Application No: BN/7/22/HH
Site Address: 10 Downview Road Barnham PO22 0EE
Description of works: Erection of outbuilding to rear.

Thank you for your internet representation made on 17th March 2022 which has been recorded as no objection with the comments as follows:

PROPOSED FRONT ELEVATION
(scale 1:50)

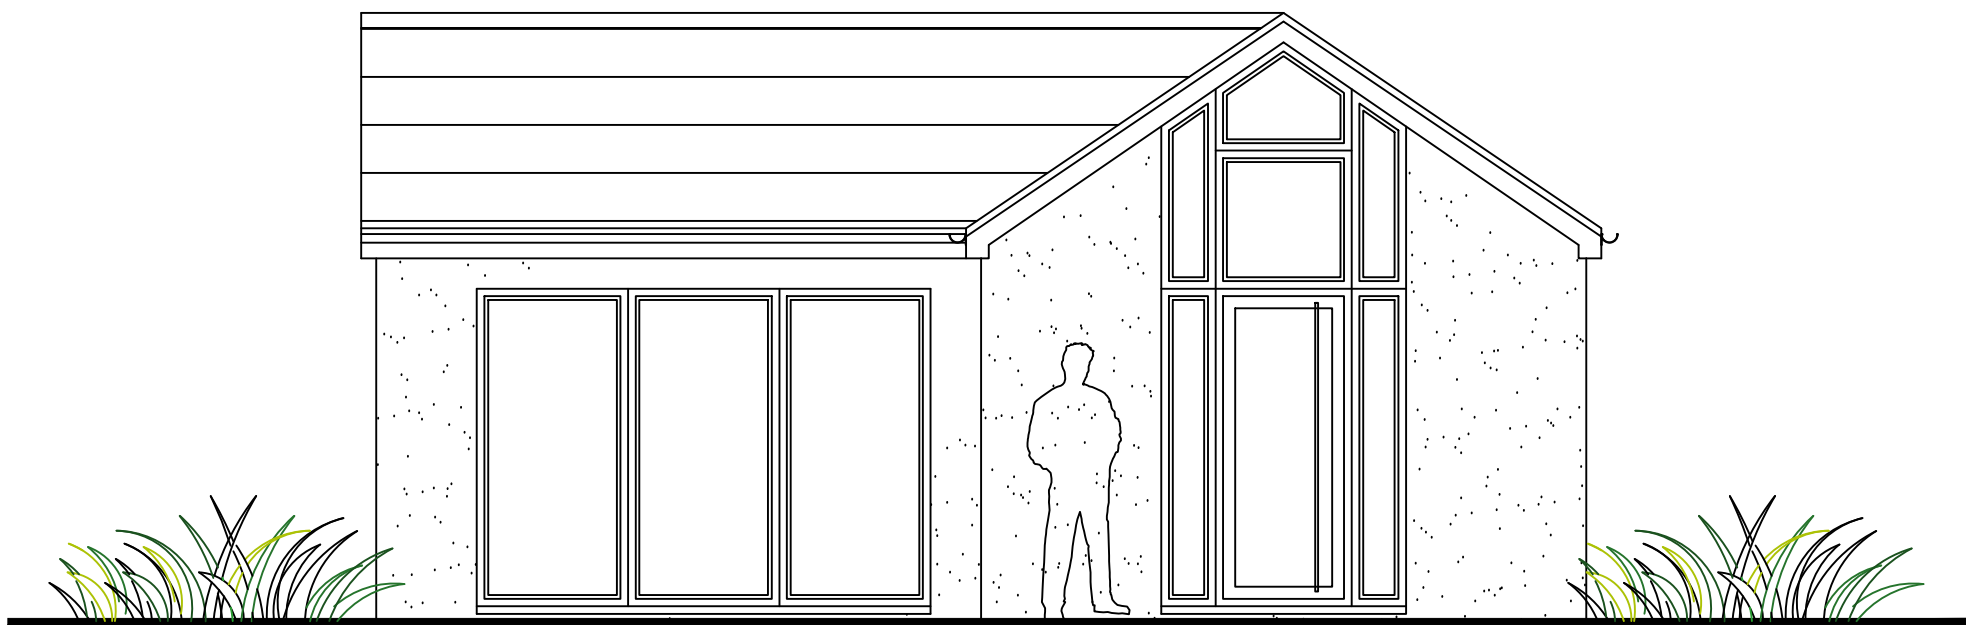
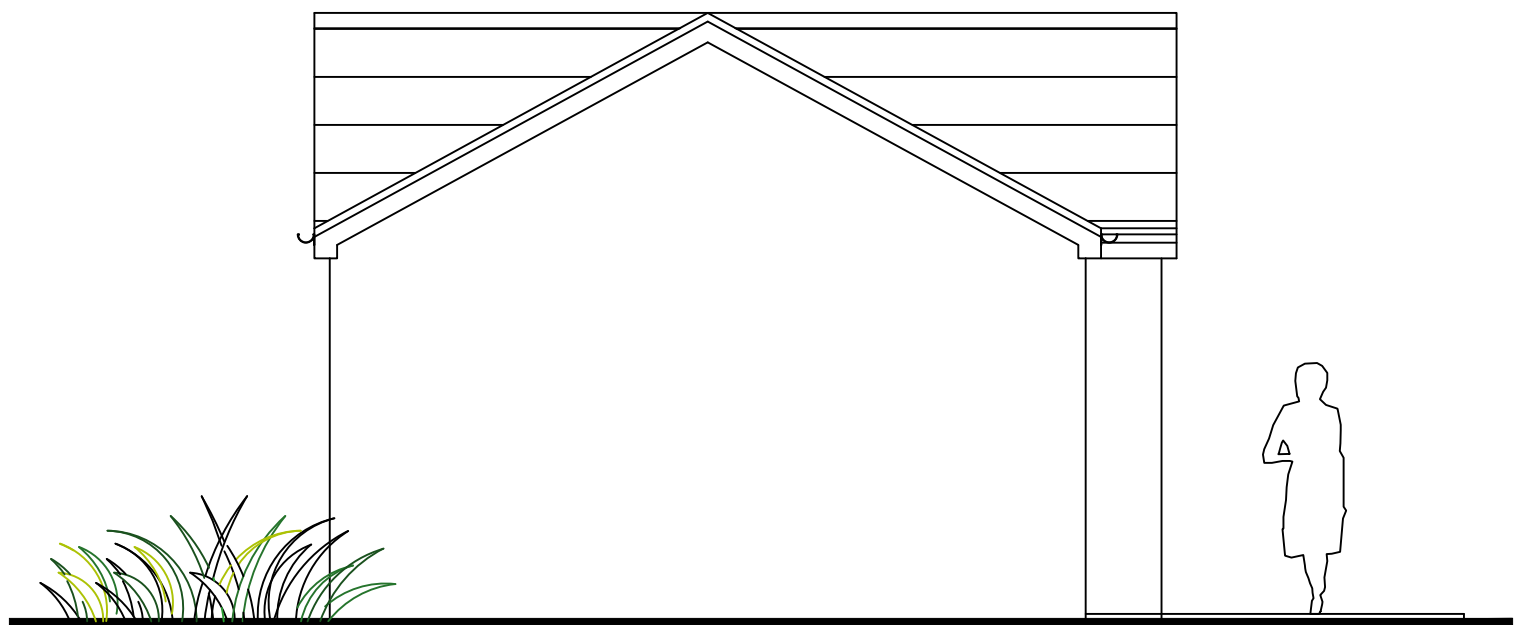
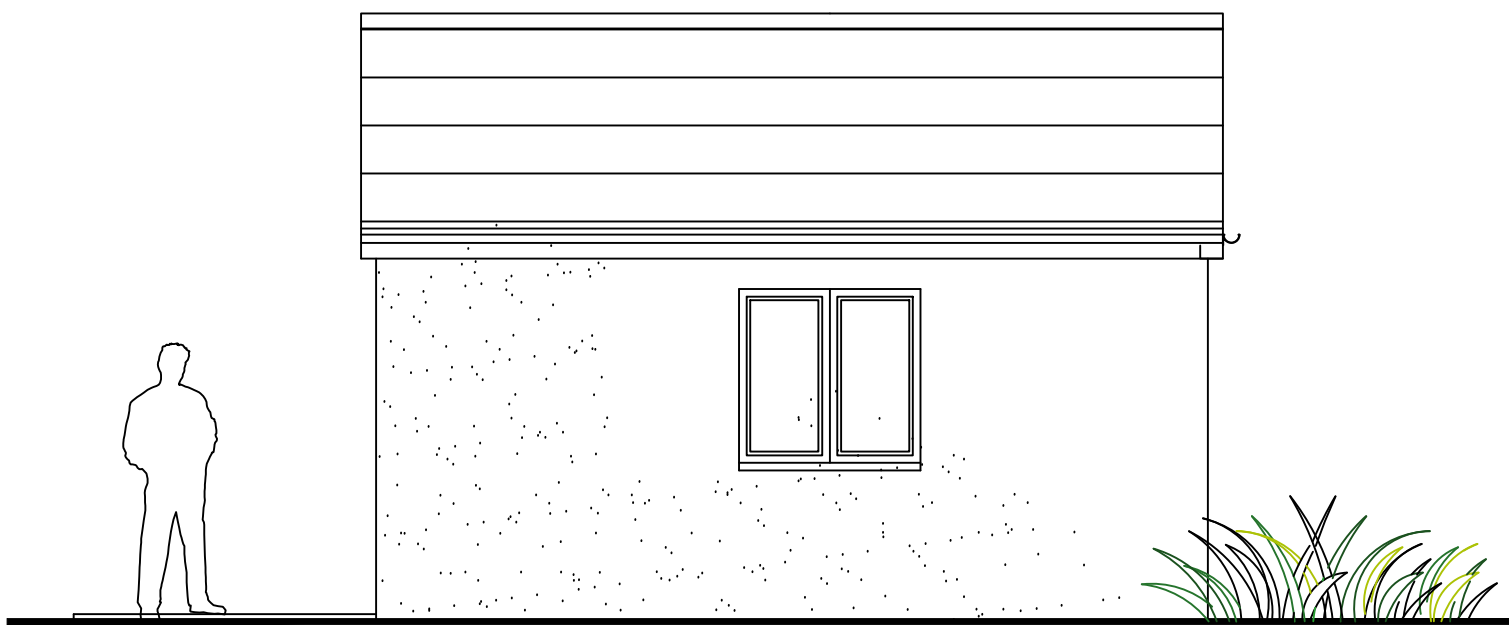
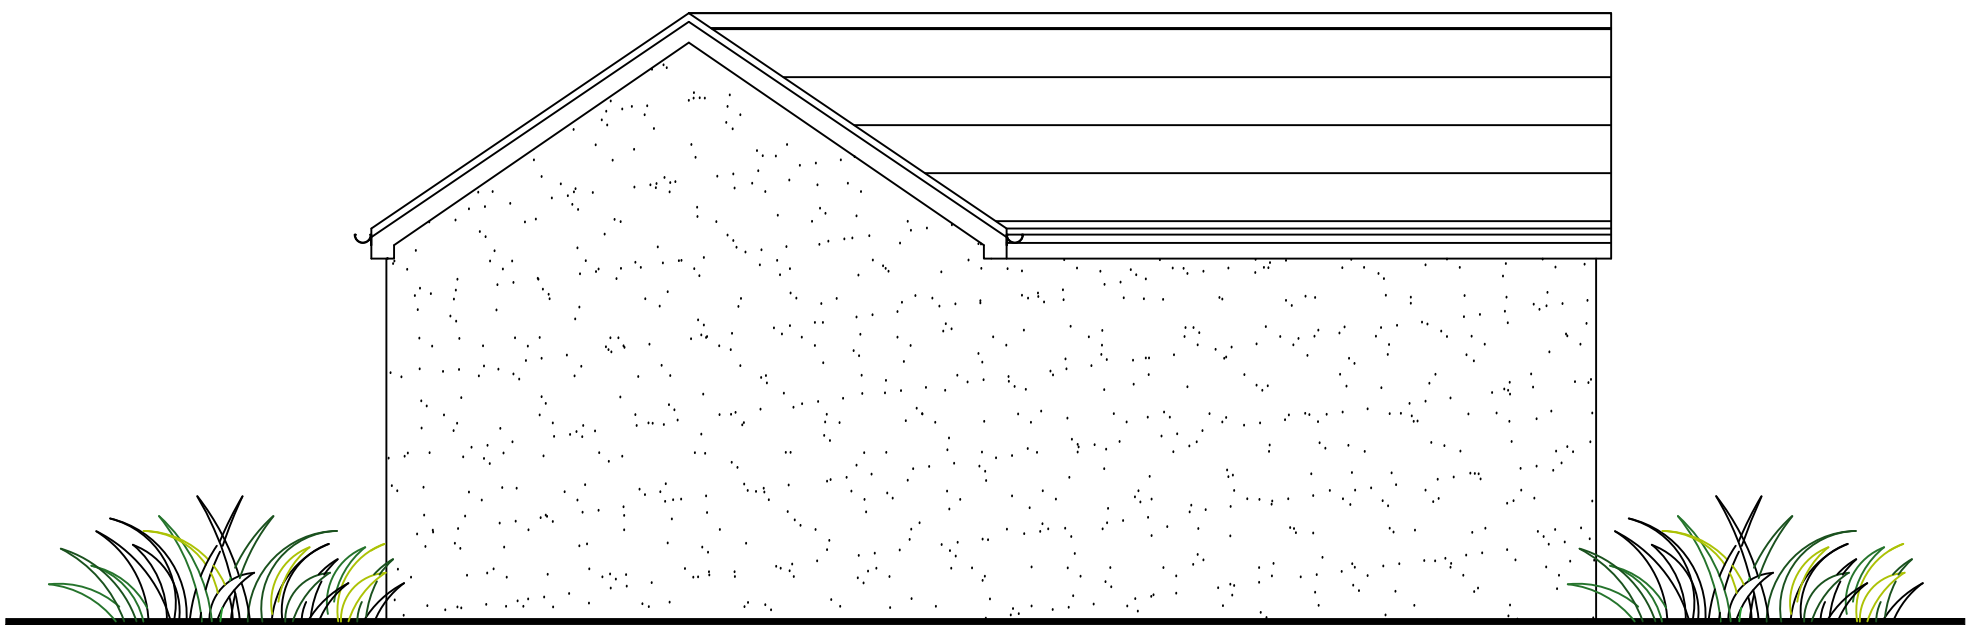
To that objective I would like conditions imposed on any approval limiting the height to 4.5m as proposed, the external appearance should be sympathetic to its surroundings, its foundations should not adversely impact the mature trees at the end of the garden and that it may not be subsequently converted for 24hr / overnight occupation.

PROPOSED SITE PLAN
scale 1:200

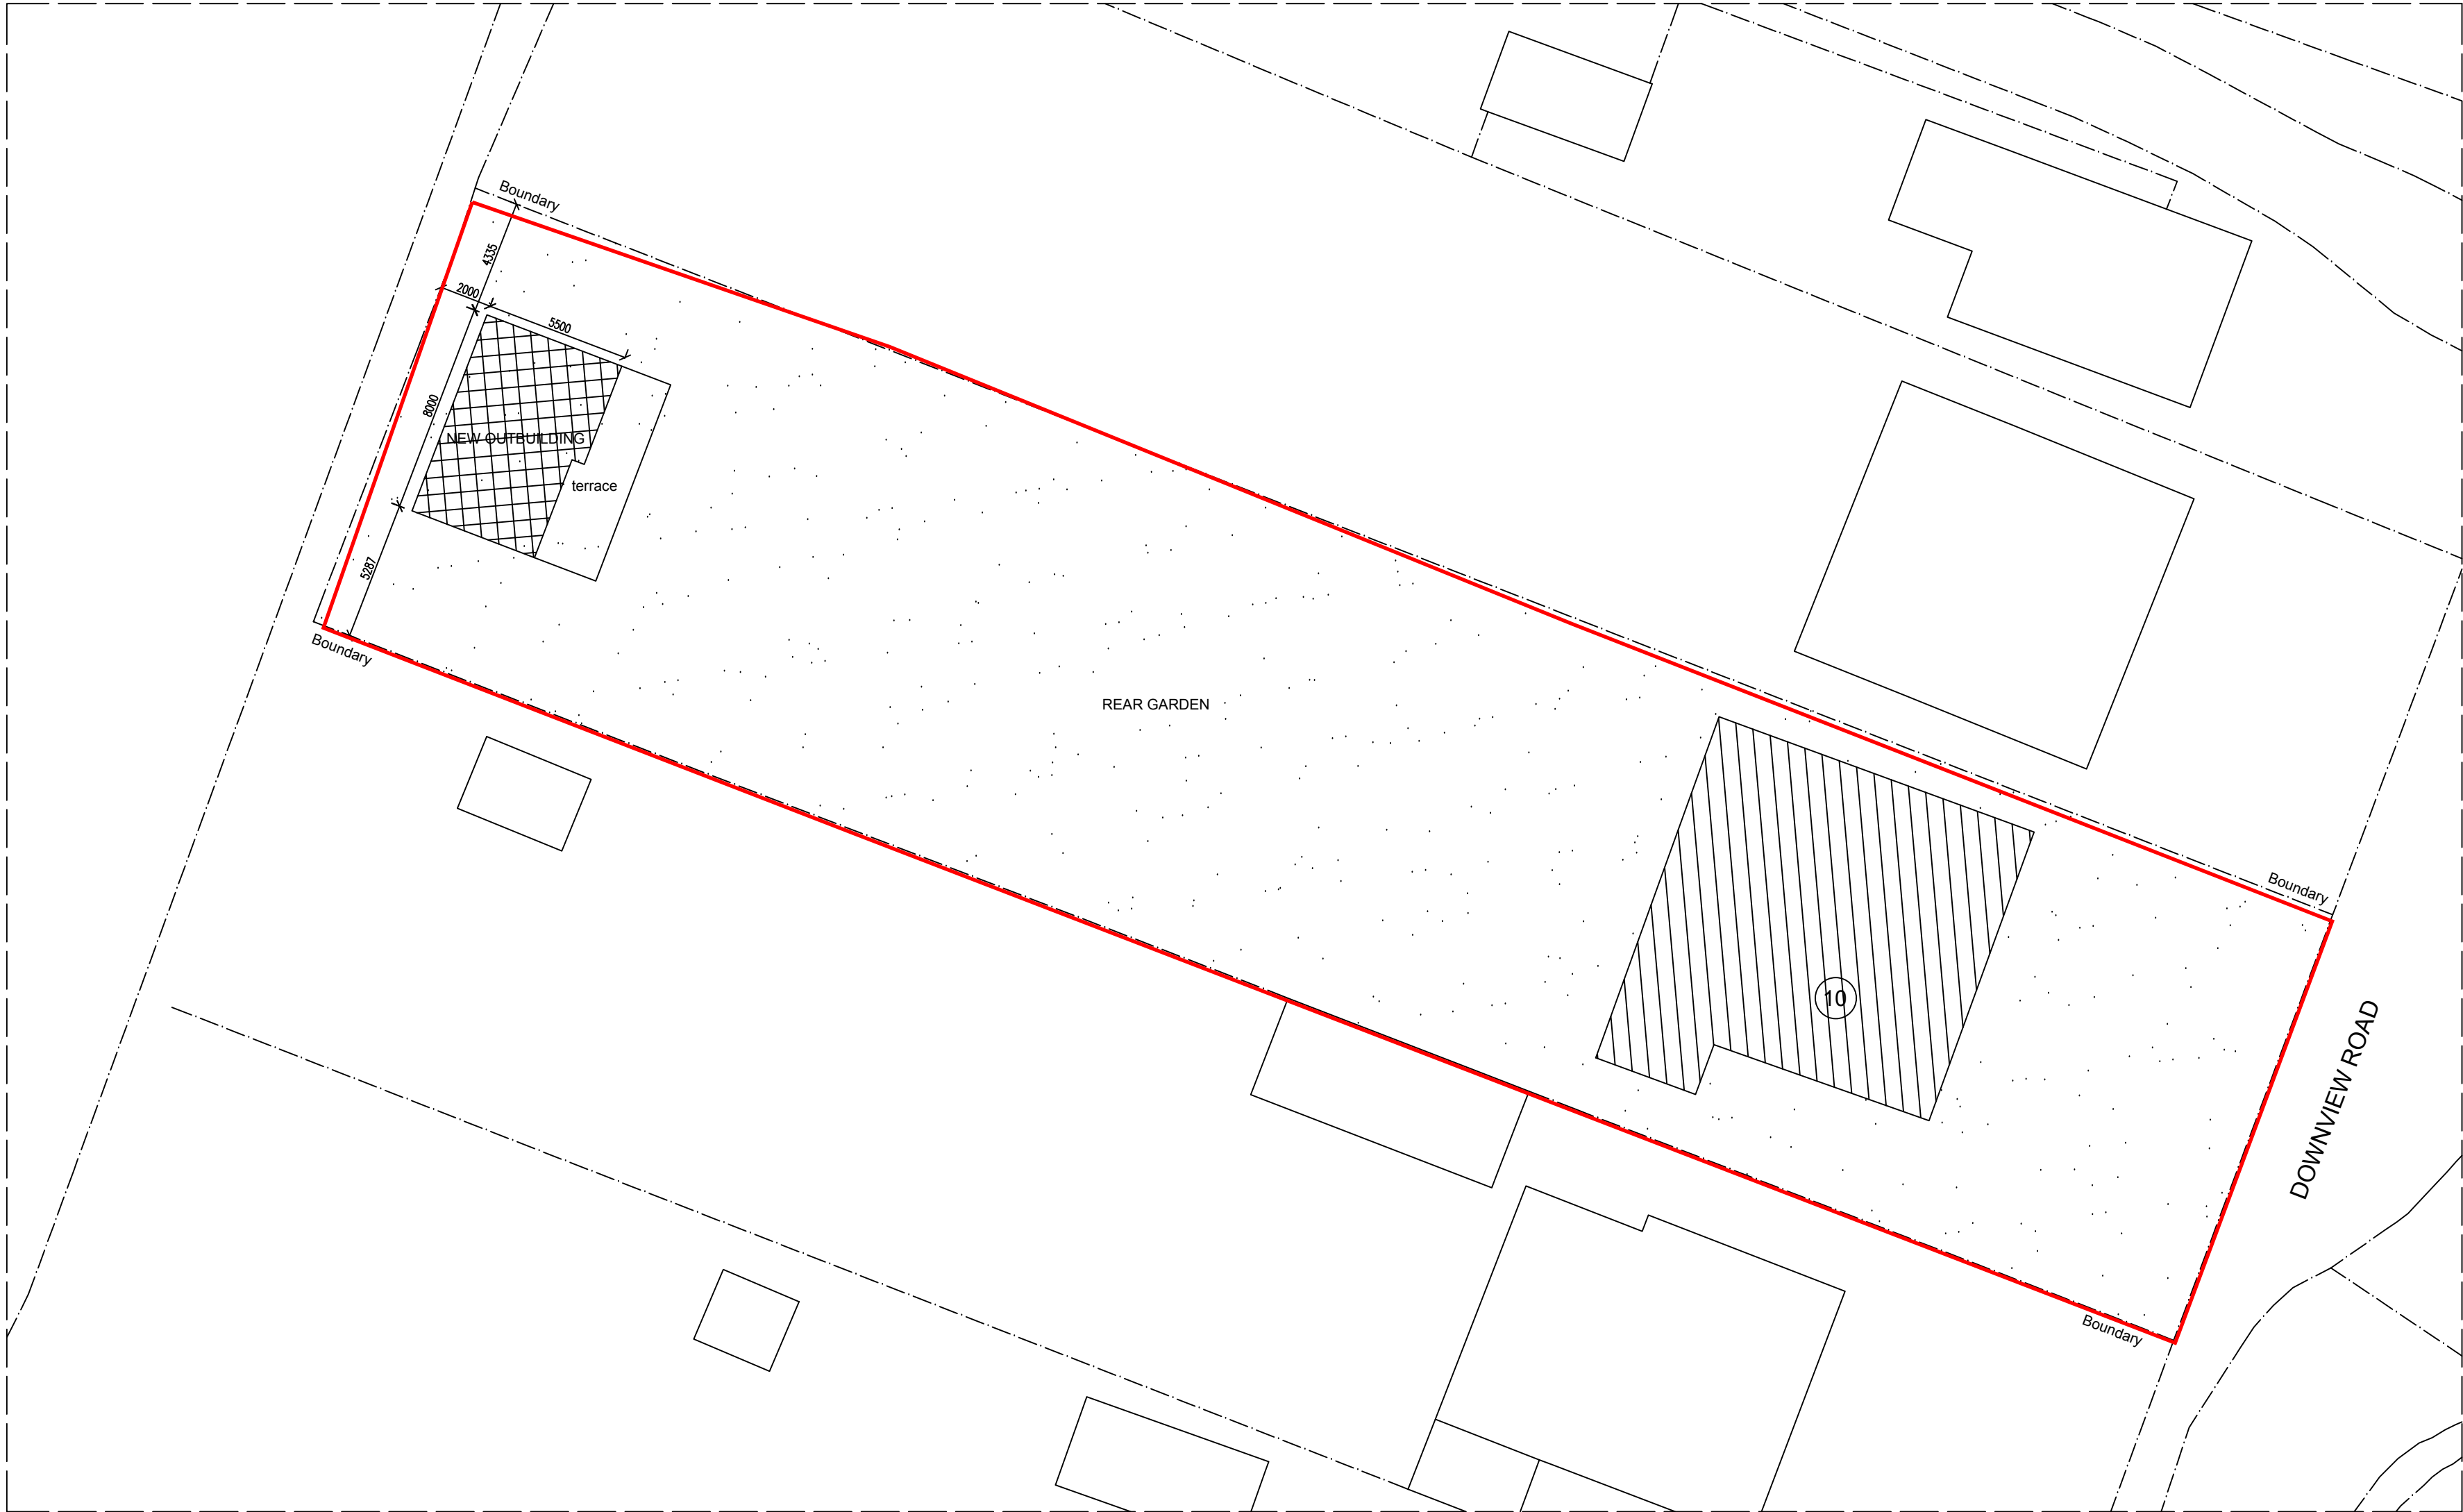
I have no objection in principle to the proposed building, which is next door, but would like to ensure that it is built just as indicated on the plans and in a way that will not damage the trees, understood to be Hornbeam, at the end of the garden and will not unduly impact our lives.
